**Application Reference:** 2024/0689

**Site Address:** 12 Lakeland Close, Cudworth, Barnsley, S72 8SL

This application seeks planning permission for the erection of single storey outbuilding to rear, and detached garage to side of 2 storey detached dwelling

**Proposed Ground Floor Plan**  
Scale 1:50

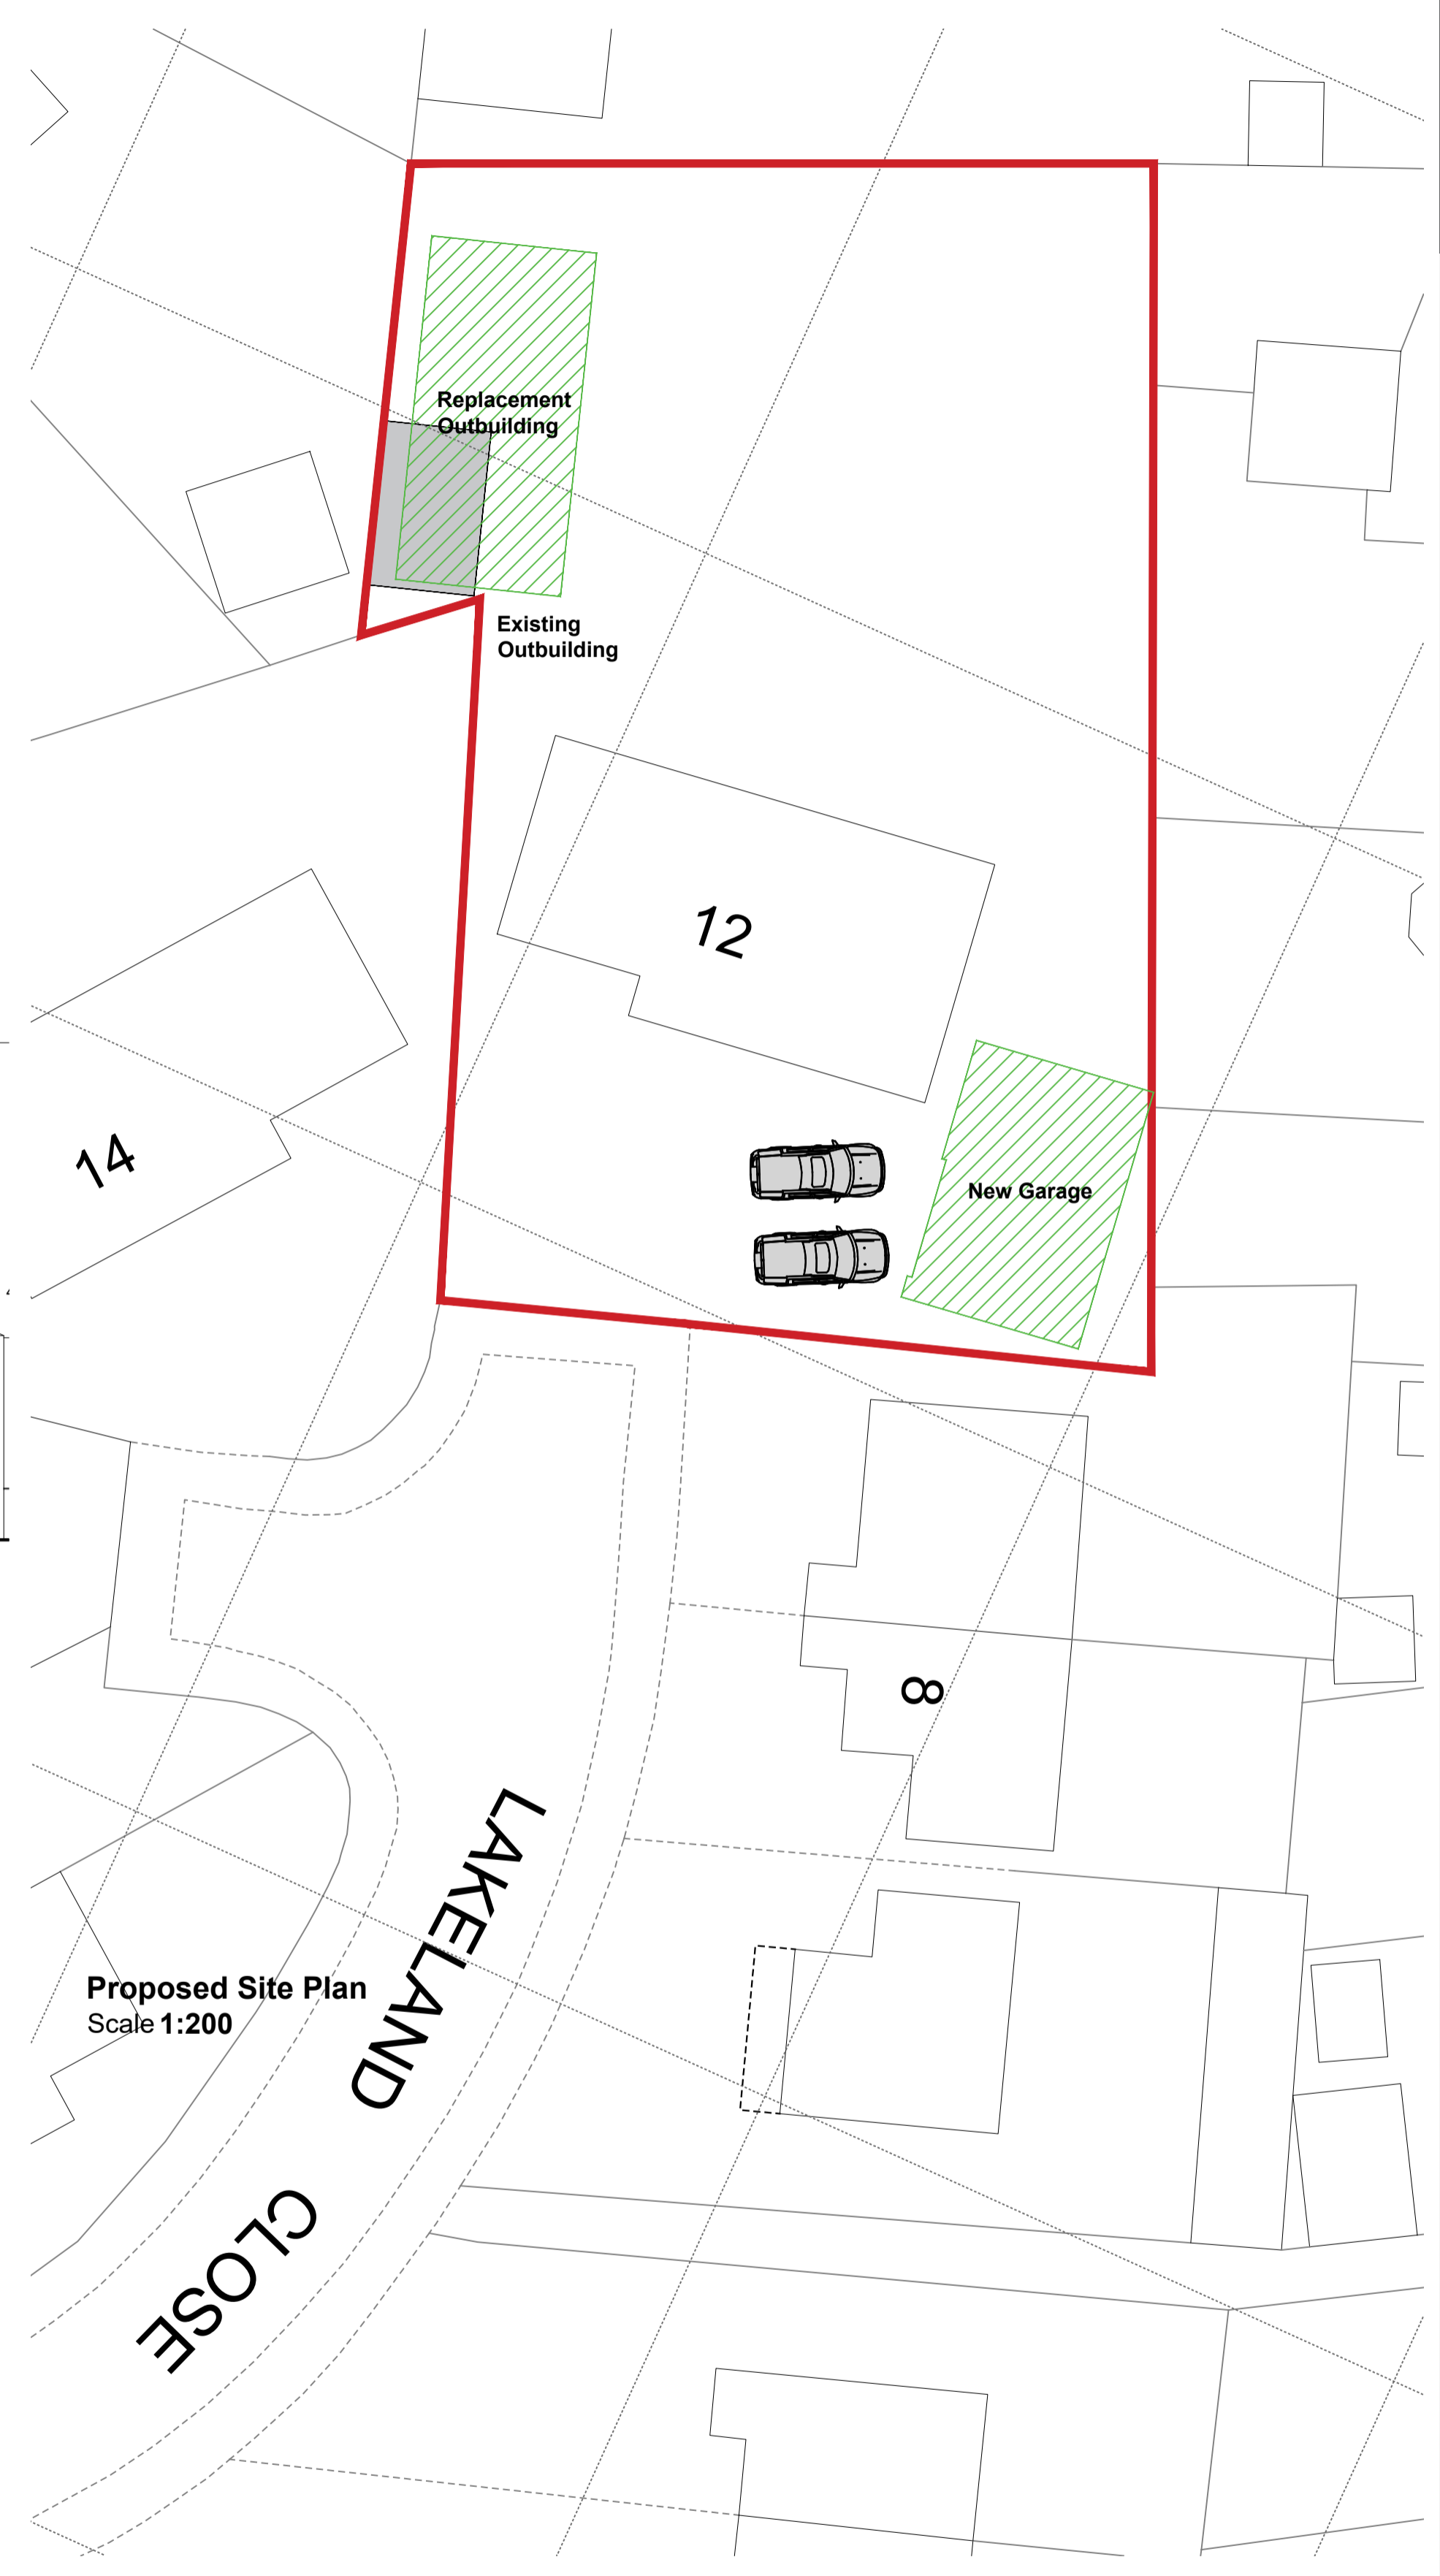
The second part of the proposal is for a detached outbuilding, in replacement of an existing smaller outbuilding, located in the rear garden, adjacent to the western boundary with a neighbouring rear garden, and a small area of southern boundary with a different neighbouring rear garden. Similarly to the garage, the proposed outbuilding has been reduced in scale and would also be constructed of brick and feature a tiled, dual pitched roof. The approximate length of the proposal running along the western boundary would be approximately 15.42m, whilst the proposed width would be 6m. Due to possible differences in ground level, the eaves vary in height between 2.35m and 2.5m high, but the roof remains at a constant height of 4m. Internally the proposal would feature two sections, the first, a kitchen and entertaining space,

and a separate room, more akin to a storage area, for the installation with a hot tub. The front elevation overlooking the garden would feature full height window and a separate Bi-fold glazed doors, but the section including the hot tub would feature roller shutters or similar.

In mitigation of the outbuilding's size is its location and subservience to the main dwelling. It is out of view of the street scene and would take up less than 20% of the rear garden area leaving a large private amenity space remaining. Given the two storey nature of the existing dwelling the size of the outbuilding would remain subservient to the main property and, if located approximately 1m further away from the boundary, would be classed as permitted development. The materials and design are in keeping with the existing property so it would not appear as a prominent or discordant feature, Whilst it's size is not in line with the SPD, in this instance the circumstances of the site mean the large size does not cause any significant detriment to the site or its surroundings to warrant refusal of the application. However, a condition is recommended so it remains ancillary to the main dwelling.

With the proposed outbuilding being of a size allowable through permitted development, the only thing preventing the application being constructed through this method is its location within 2m of the boundary treatment. With a high hedgerow separating the proposed outbuilding from the neighbouring garden, and an approximate 1m distance from the rear boundary treatments, it would seem unreasonable to request the proposal was removed 1m further into the garden when it would have no positive impact on the amenity of the neighbouring dwellings. Moreover, whilst the proposal is larger than the existing outbuilding, the existing outbuilding is situated directly adjacent to the boundary. With the proposed used of the outbuilding for entertainment and leisure purposes, whilst there may be some additional noise created, it would not be expected to be above anything experienced by other leisure activities undertaken within a garden. In consideration of all aspects, the proposal would be expected to have no more than a limited impact on the neighbouring amenity of neighbouring dwellings.
